October 22, 2021

Re: Letter of Intent for Mountain View Electric Fiber infrastructure

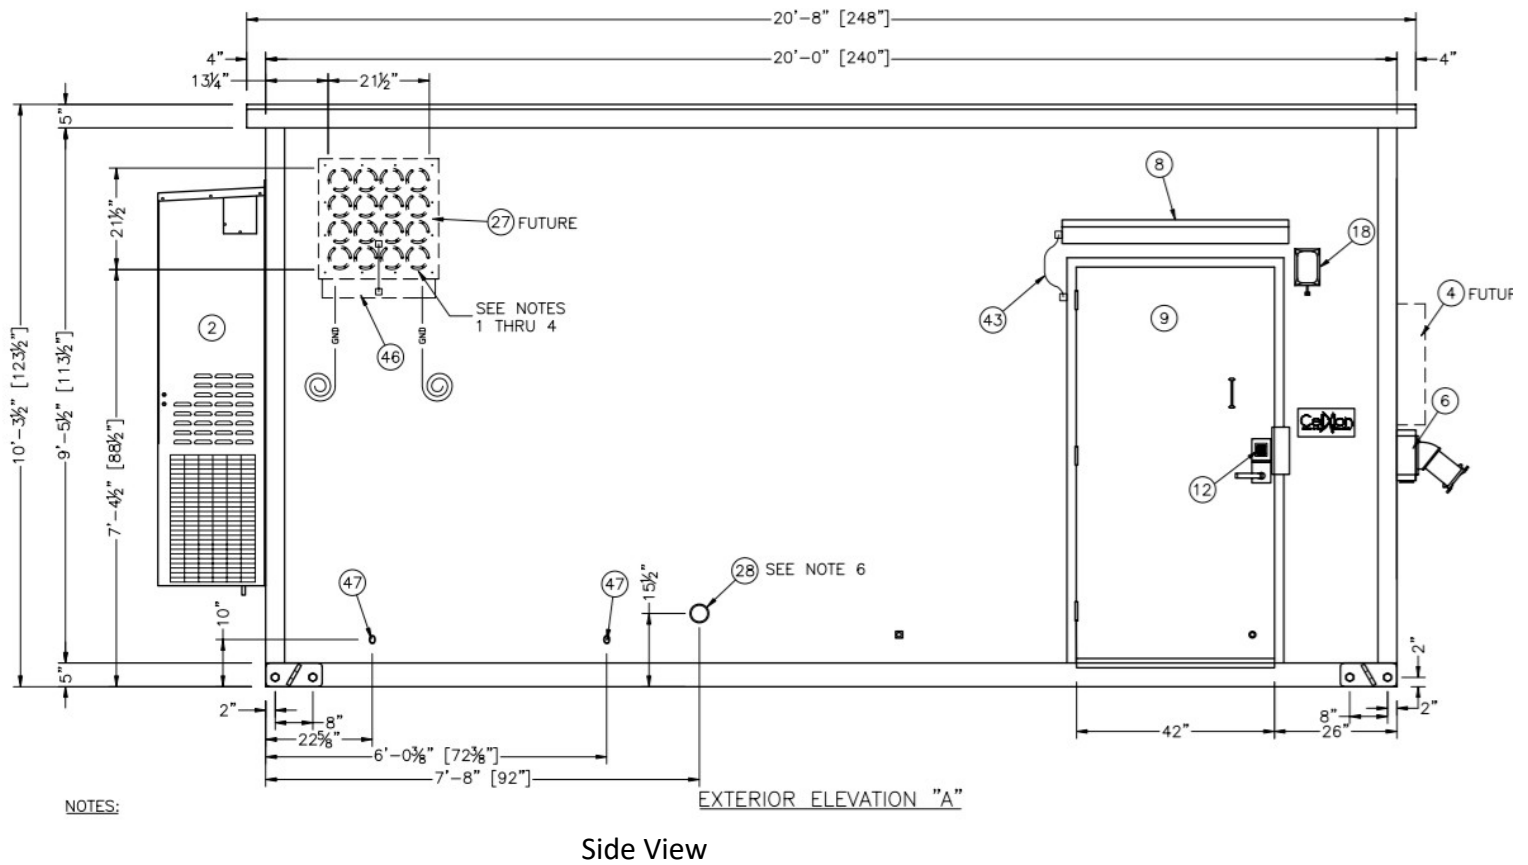
Are any other structures going to be built throughout the County?

This is a very broad overview of the project map. Due to the scale we can not provide anything more detailed.
